Re: 4545 Alameda NE–Grading & Drainage Plan
Lot 5A, Richfield Park Subdivision

(C17-D120)
P.E. Stamp: 8-29-12

From: Olson, Greg R. [mailto:groolson@cabq.gov]
Sent: Wednesday, August 29, 2012 10:57 AM
To: AsaW@iacivil.com
Cc: Olson, Greg R.; BryanB@iacivil.com
Subject: C17-D120 Richfield Park Lot 5A "Verbal NO"

Per our phone conversation this AM, the Grading & Drainage plan for this site is generally acceptable, but cannot be approved until the following exceptions are addressed:

HEADWALL B: BETWEEN PONDS 1 AND 2

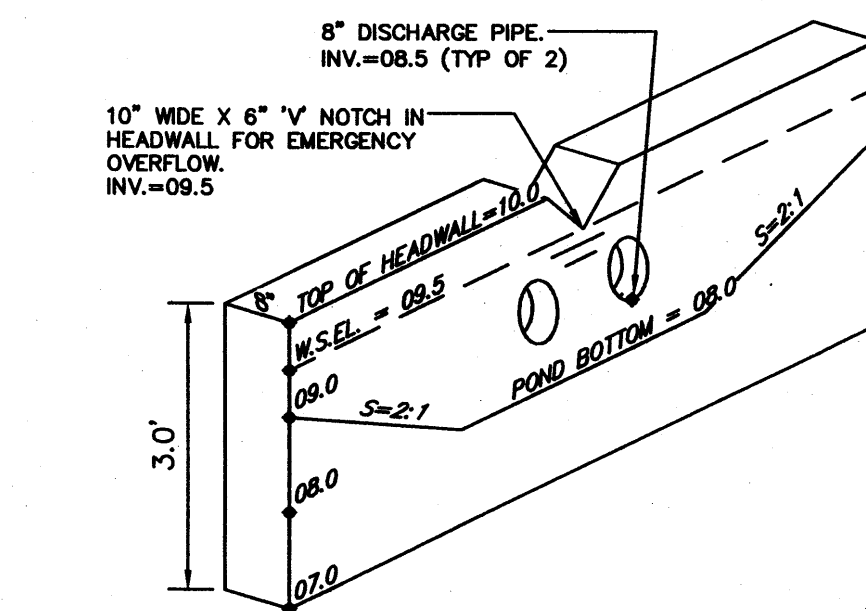
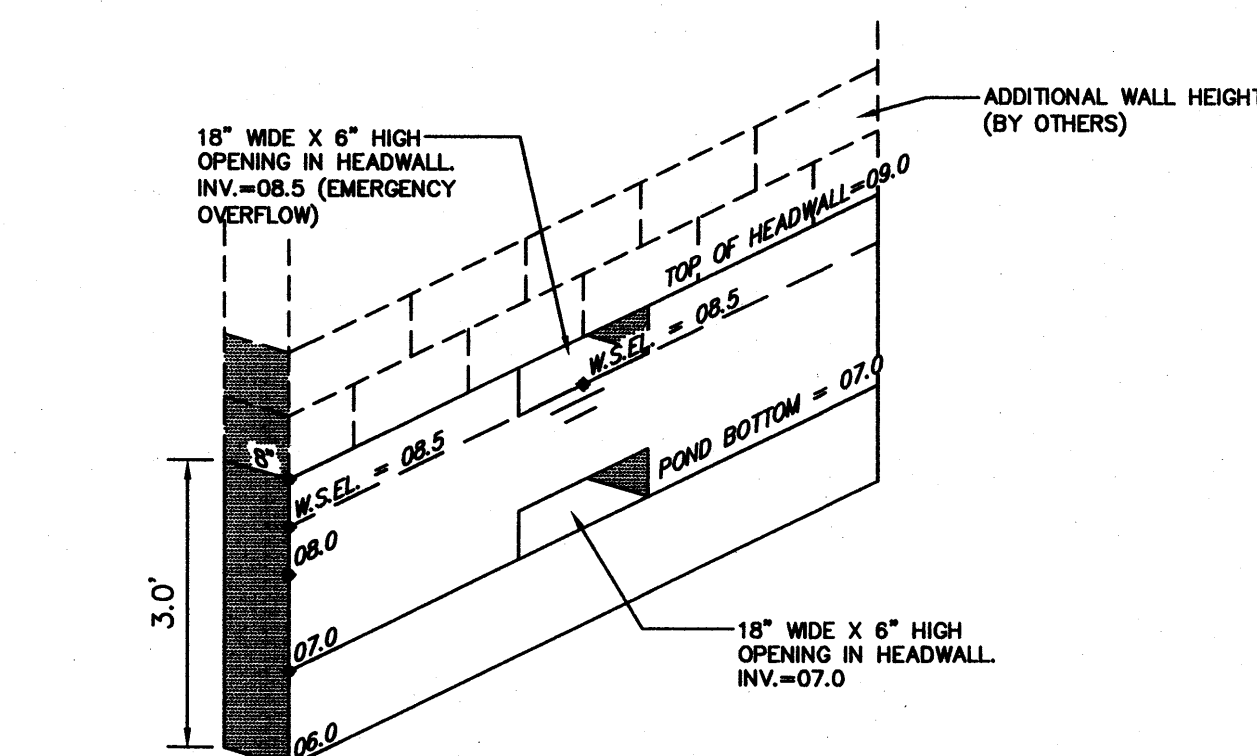
- d. Sh. CG-501: The lower of the two Headwall A Details appears to represent Headwall B.
Please clarify/re-label.

We have taken care of items 2a through 2d from your review comments. As part of the resubmittal, we included the attached photo (see below) in our response letter. This photo shows the adjacent property to the east has been 'developed' to some extent. We included the following explanation in our resubmittal letter:

GRADING AND DRAINAGE PLAN

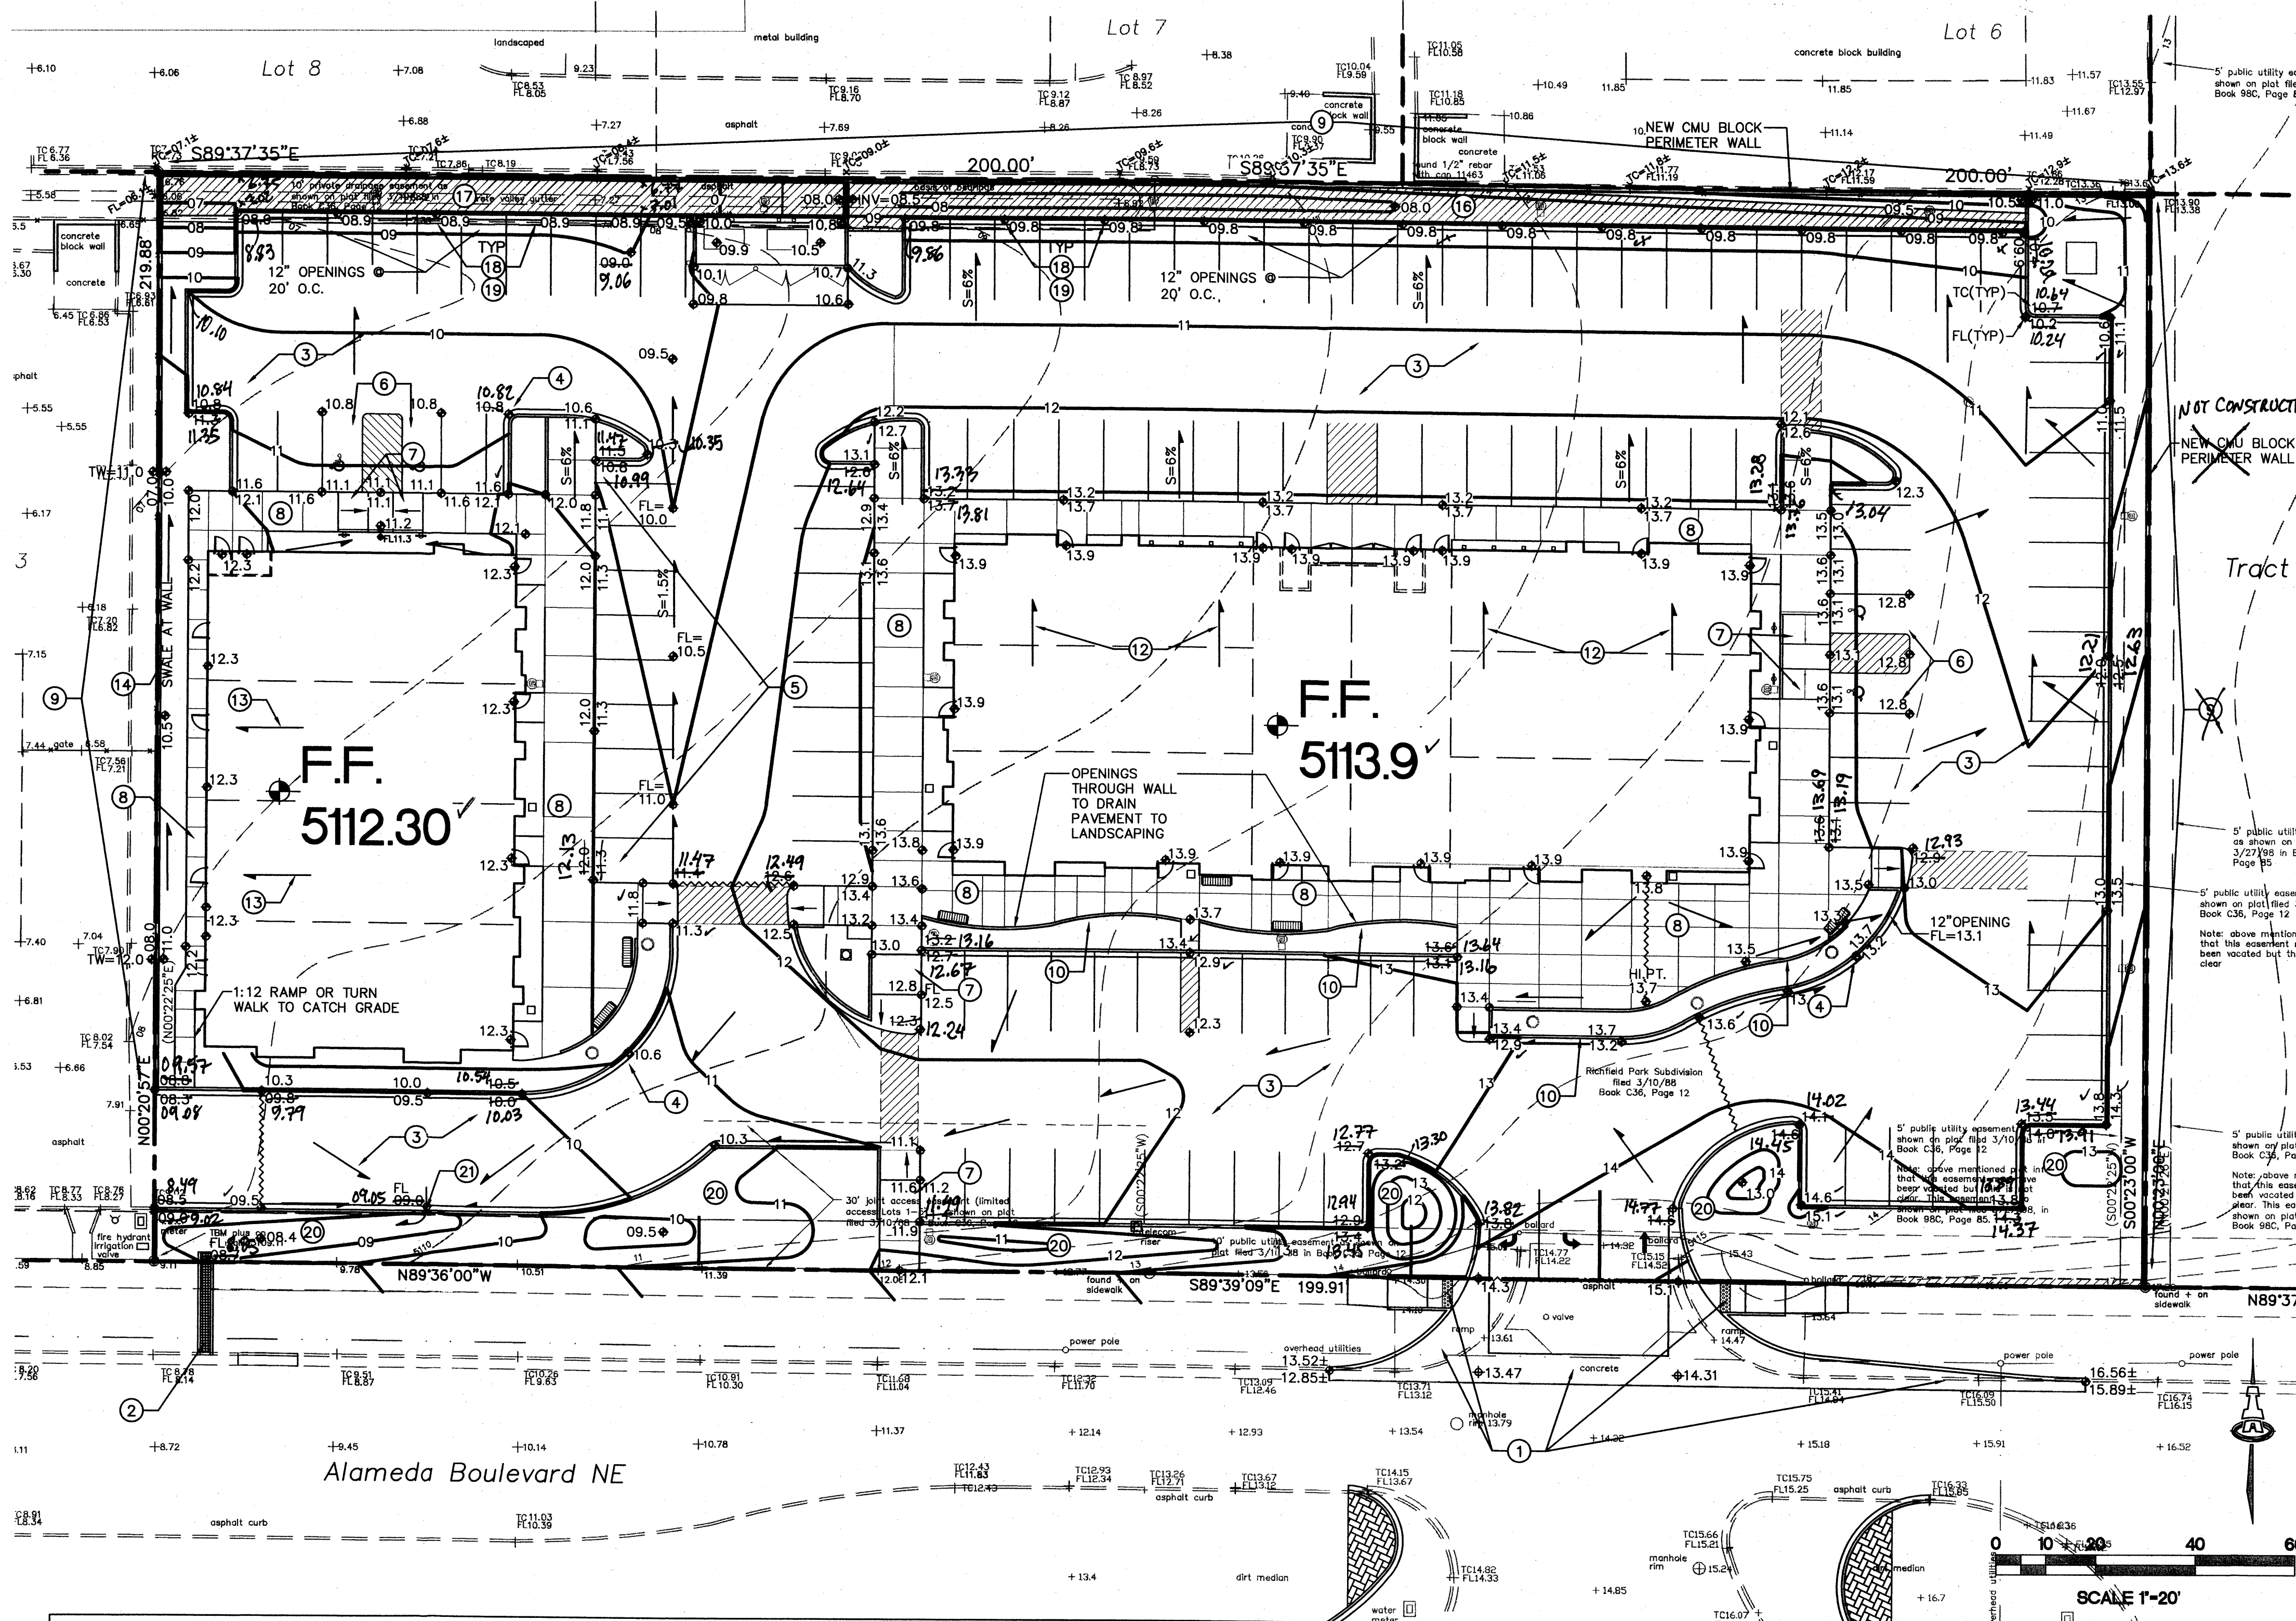
1. The proposed wall on the east boundary appears to block offsite flows from Lot D1A, which may pond behind the wall, or be directed northerly along the property line. Contours shown suggest that these channelized flows (which by the Drainage Master Plan should go to Columbine Road) may cross over into the east side of Lot 6, north of your site. Provide more detail as to how these offsite flows will be routed after construction of the wall. If offsite grading is required to deal with this situation, we will require written permission from the owners of the offsite parcel(s).

2. Address drafting details on the plans as follows:
 - a. Sh. CG-101: Key Note 2 should include a width for the Sidewalk Culvert.
 - b. Sh. CG-101: Provide Flow arrows in the swale along the west side of the lot.

- c. Sh. CG-101: Call out a curb opening and width at the low point in the driving lane south curb approx. 60' ENE of the SW corner of the site (at El. 9.0).

Here are some additional photos that will help show that the proposed wall is not changing the existing flow pattern. As part of the recent milling overlay, the property owner to the east graded a defined berm transitioning to a swale at the northwest corner of his property. This was probably done to prevent "developed" flow from passing onto our client's property.

Because the adjacent property has been partially developed and graded to deflect flows to the north per the master drainage plan, the proposed wall at the east side of our site should not be considered as deflecting historic offsite flow. We believe that since the historic flow pattern has been altered by the adjacent development, the adjacent property owner is responsible for that flow and how it is routed per the master drainage plan.

1. No offsite flow passes to the property from the east. The photo below shows the east property graded with asphalt millings to serve as an overflow parking area (by others). A deflection berm at the joint property line deflects sheetflow to the north to follow the required drainage path for Parcel C1-D. In addition, a perimeter wall proposed as part of the Lot 5A construction which will also serve to deflect offsite flow.

The existing topo contours show a minor slope from south to north. The photo shows a small deflection berm. In addition, I have discussed the concern with John Mechenbier and he has agreed to waterproof the bottom rows of blocks. Will this suffice?
